**Peter McManus - Sydney University Student Accommodation Abercrombie Street
Darlington**

**from : Rosie Wagstaff
 27 Wilson Lane Darlington 2008**

***Modification Request for the University of Sydney Abercrombie Precinct
 Redevelopment: Application Number: MP07_0158 MOD 3***

Ground Floor Plan
1:200@A1
11.10.13
4001_DA02-D

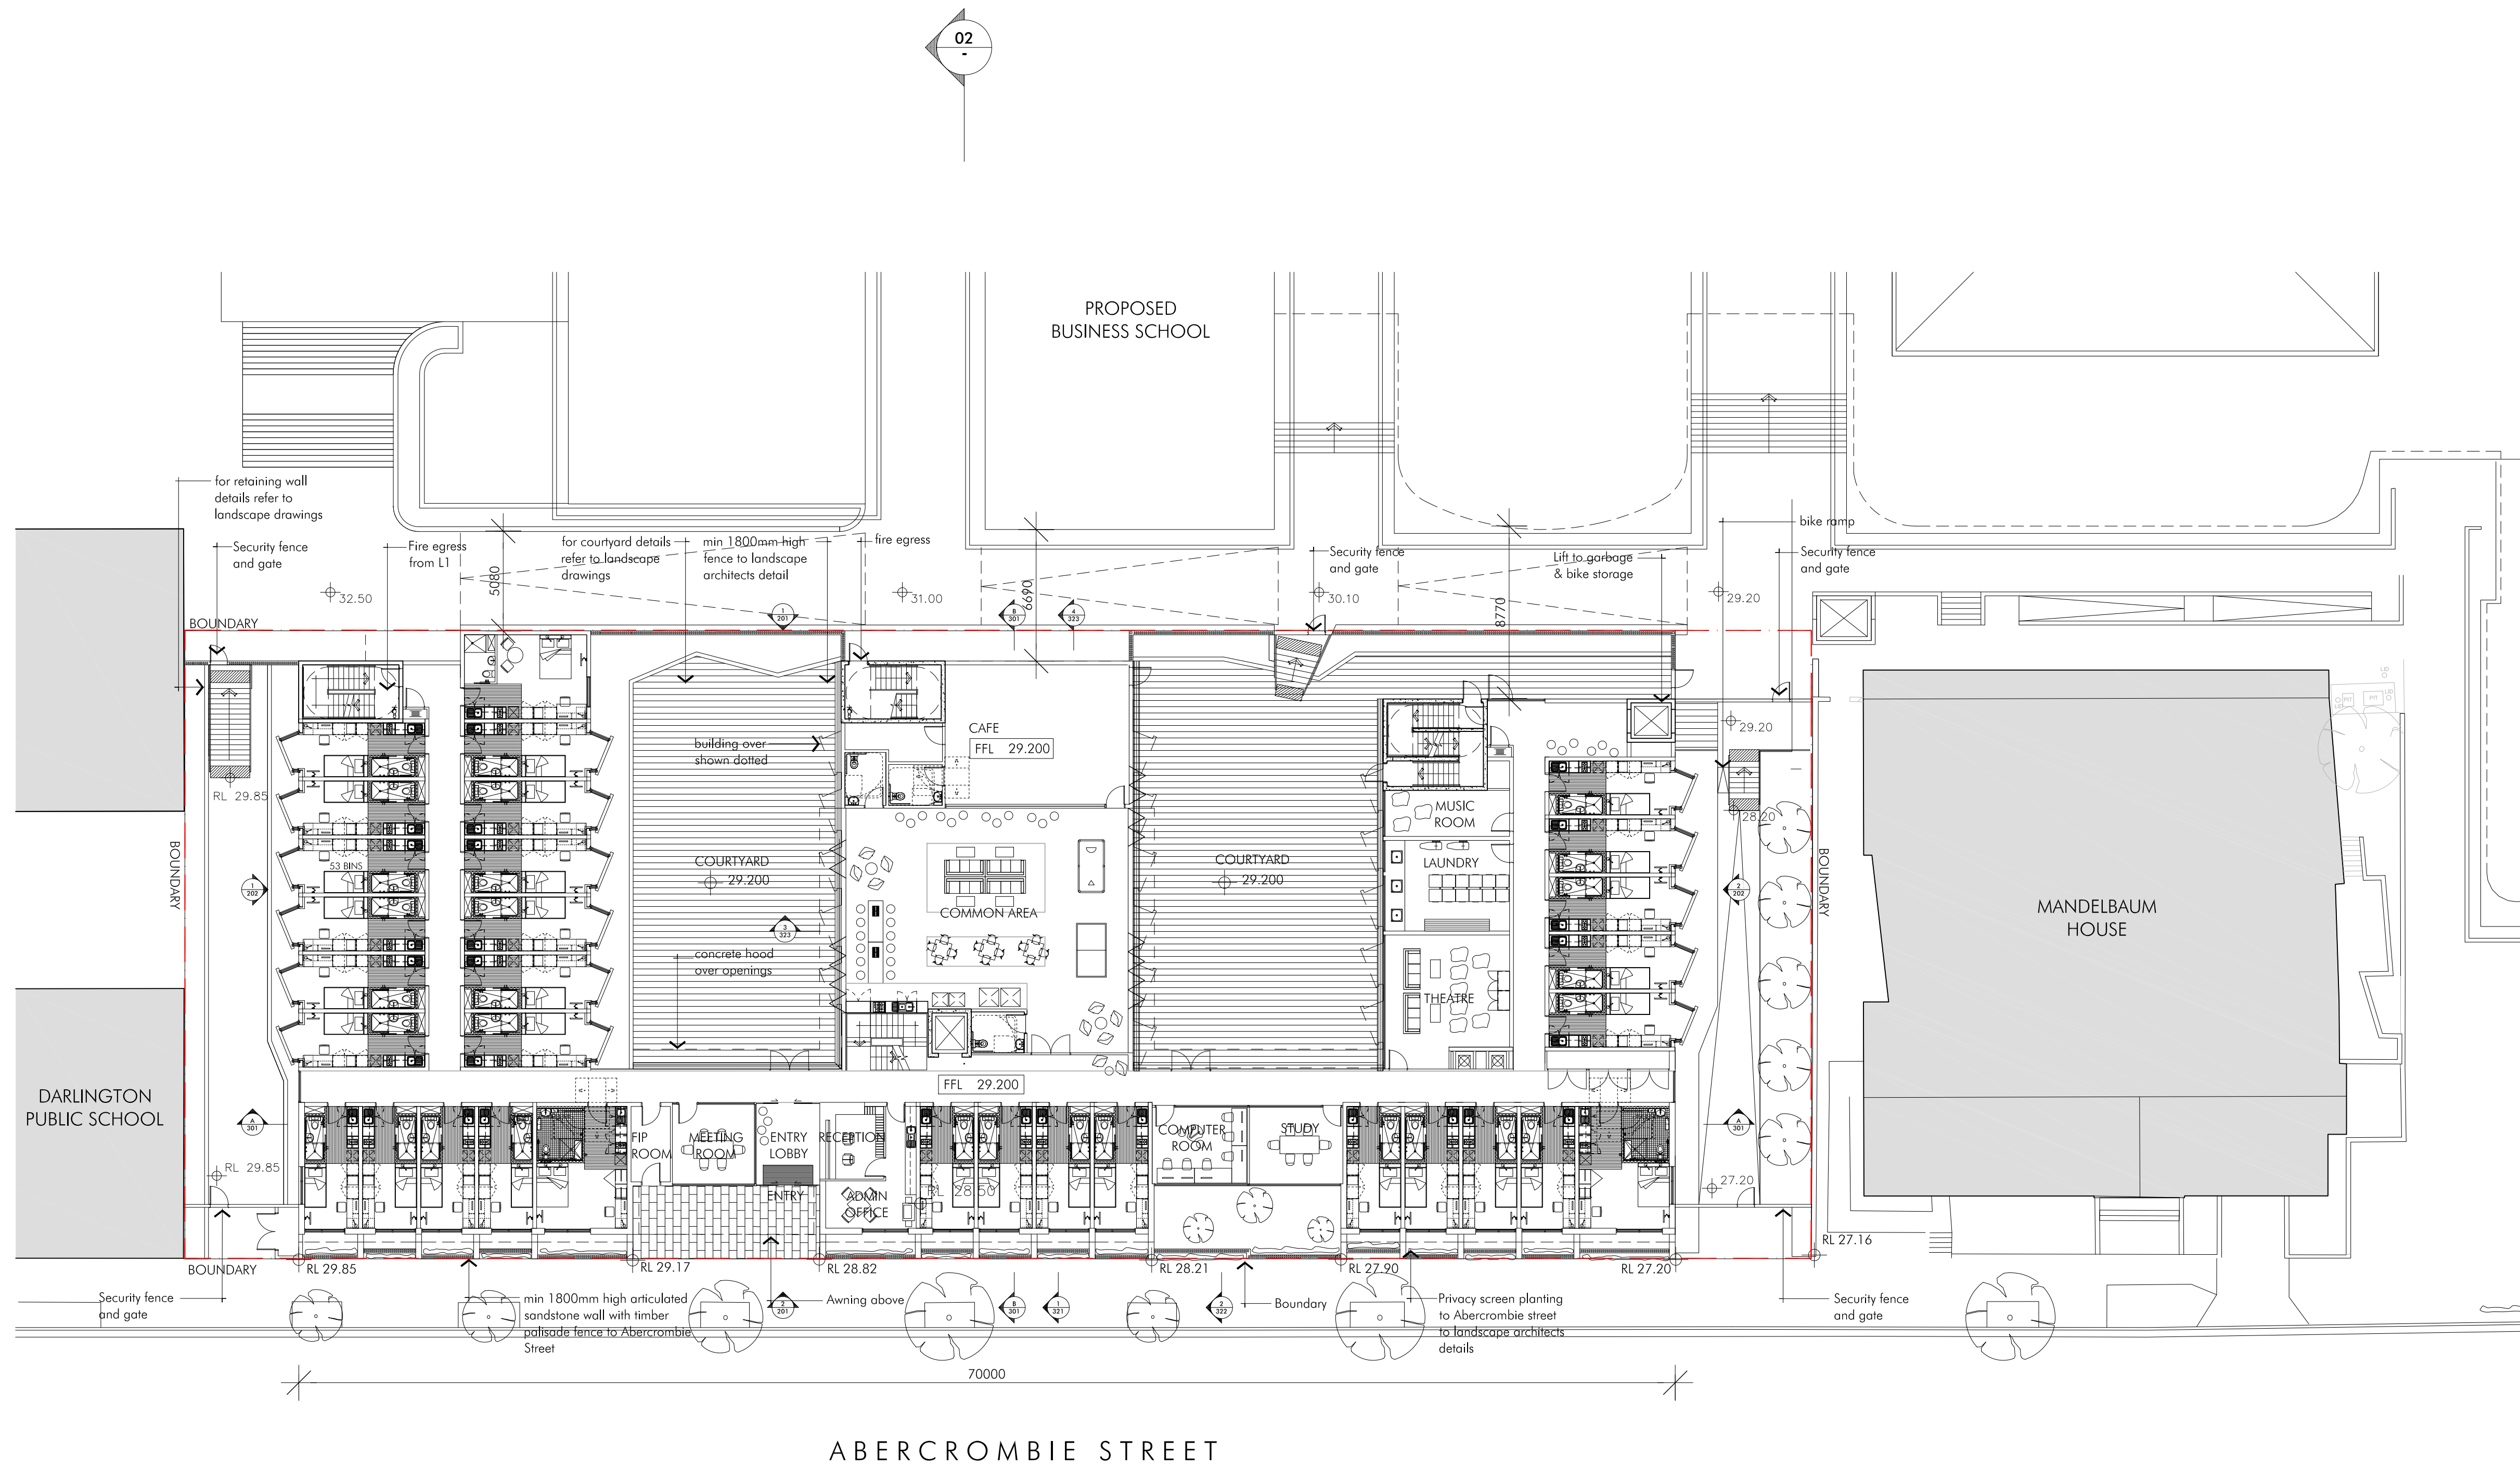
- The front of the Student Accommodation building should be built 2 metres back from the Abercrombie Street boundary. It should be set back from this boundary so that it is in line with Mandelbaum House as it was originally planned and presented to the community. The footprint of the buildings currently on the site, The Shepherd Centre and Boundary Lane Children's Centre, is approximately 2 metres back from the Abercrombie Street boundary and aligns with Mandelbaum House. Therefore, the front footprint of the proposed Student Accommodation building should be the same as those buildings currently occupying the site and as originally planned. The footprint of the proposed Student Accommodation building should not extend to the Abercrombie Street boundary.

- The facade of the proposed Student Accommodation building does not reflect the heritage appearance of the Victorian terraces opposite on Abercrombie Street as Mandelbaum House does. Therefore, it should be set back to allow for extensive vegetation and trees to be planted in front of the building on Abercrombie Street to help preserve the heritage streetscape and improve both the aesthetics and the environment of the street.
